From: Juan Baeza
Sent: 15 January 2018 16:59
To: Planning.Responses
Cc: Amanda Scholes
Subject: WA/78/17/DOC

Subject: RE: Walberton

Project: Red Cottage, West Sussex
Drawing No.: 536/501
Drawing Title: Typical Soakaway Section A-A
By: JD
Date: November 17

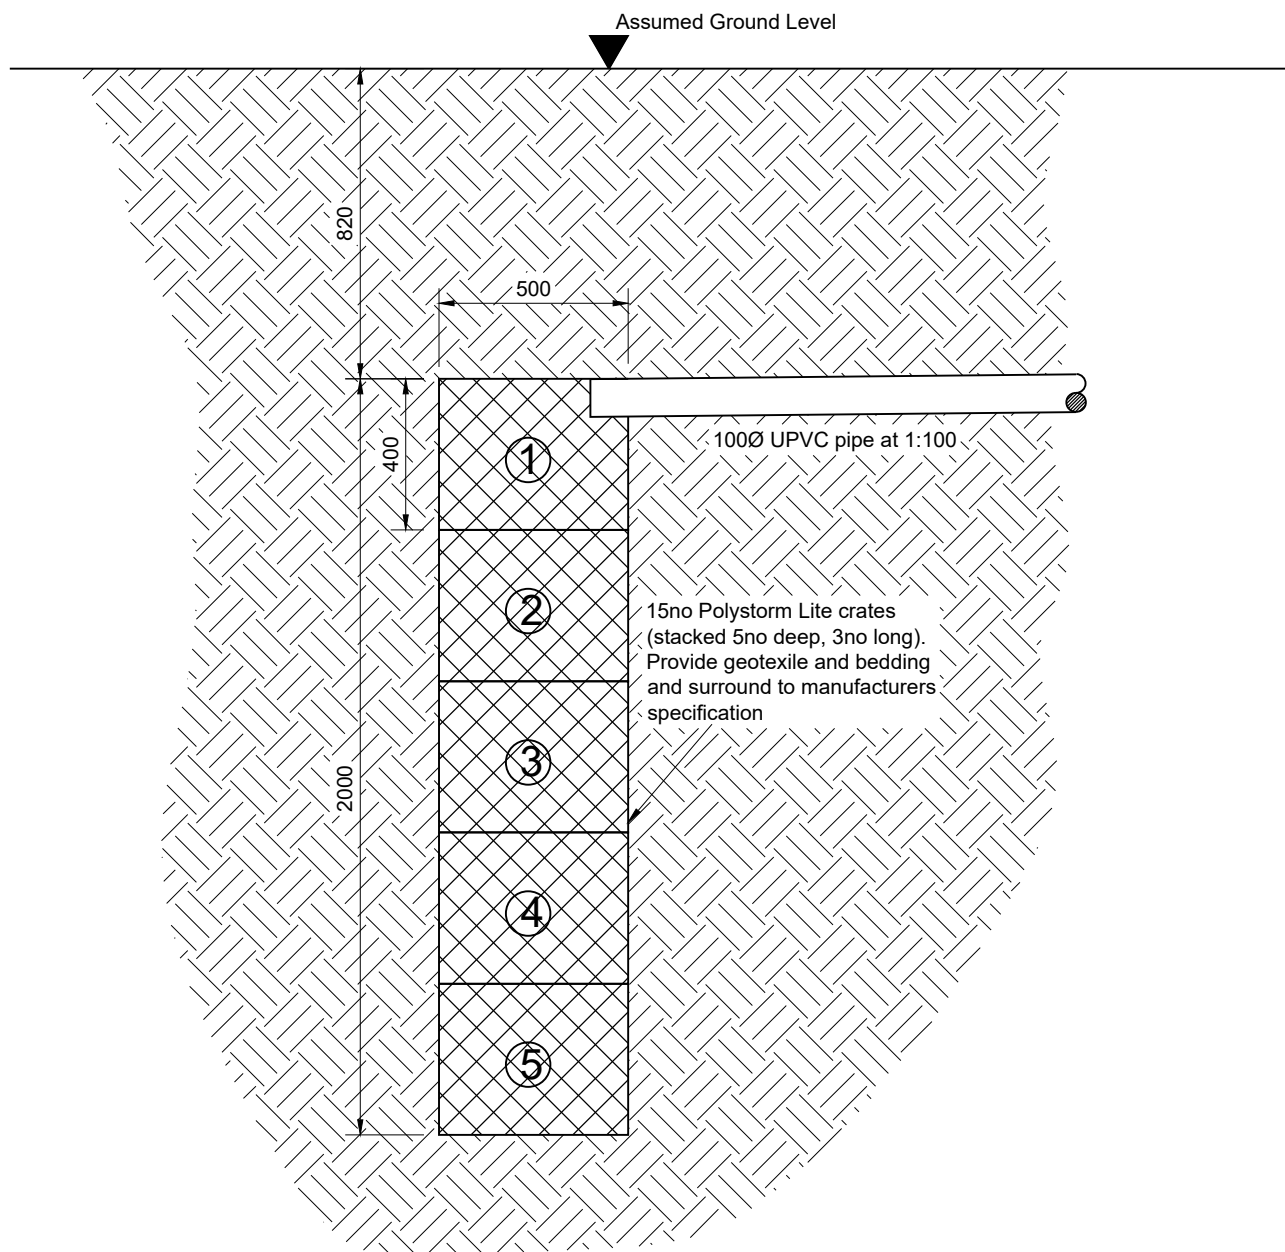
I look forward to receiving your design drawings (layout and construction details). Please note that the depth from ground level to the base of the soakaway must not exceed the depth of your trial hole.

Obviously the proposed formation level for the soakaways should not extend any deeper than your trial holes.

| Drawing Title: | Site Plan Showing Below Ground Surface Water Drainage |

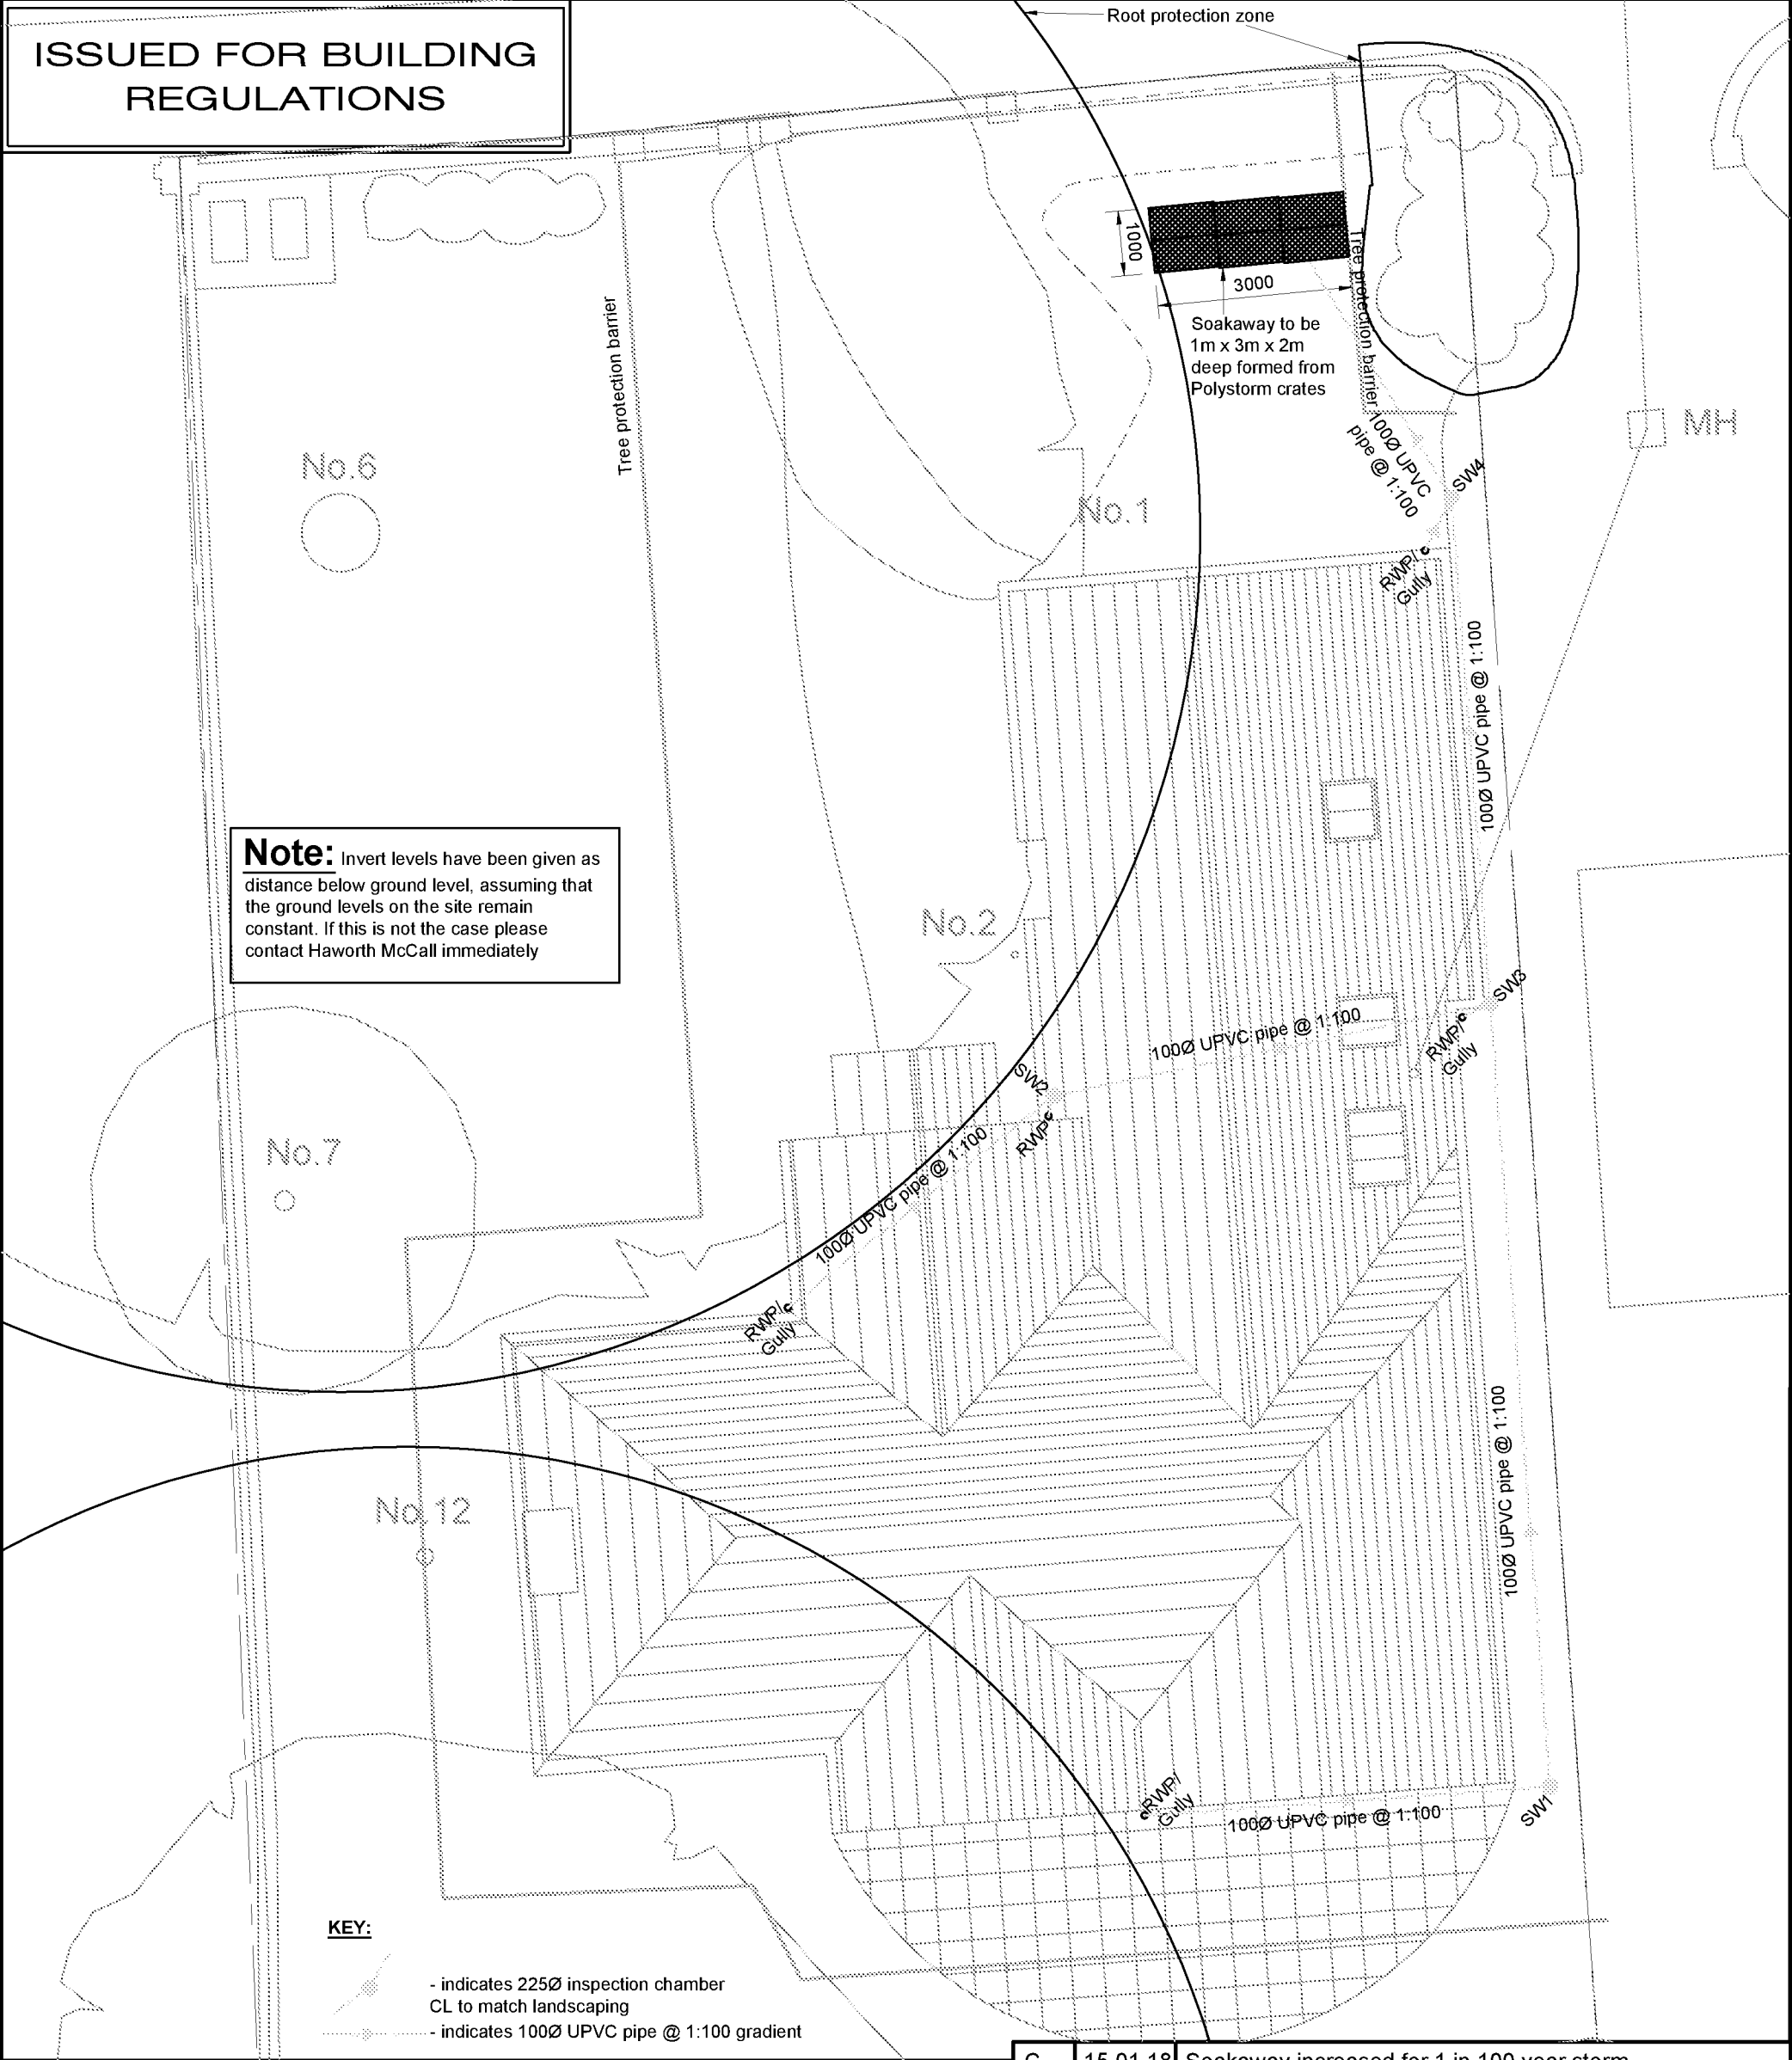
I note the percolation test results which are very good. Please forward the percolation test readings so we can check the infiltration rate, together with confirmation that groundwater was not encountered.

The chamber used to monitor ground water levels was excavated on the 4th January at approximately 11am (450mm wide by 2m deep by 3m long). There was no ground water evident in the chamber immediately after excavation. The chamber was inspected again 24hrs later and was dry. Therefore no ground water observed. Photos of the pit at the time of excavation and 24 hours later were sent to you earlier by e-mail.

(The chamber used to measure infiltration rate was 450mm wide by 2m deep by 3m long using 500mm below ground level as the chamber-full datum).

Attached is our amended drawing and soakaway calculation show the soakaway size and position using the infiltration test results above.
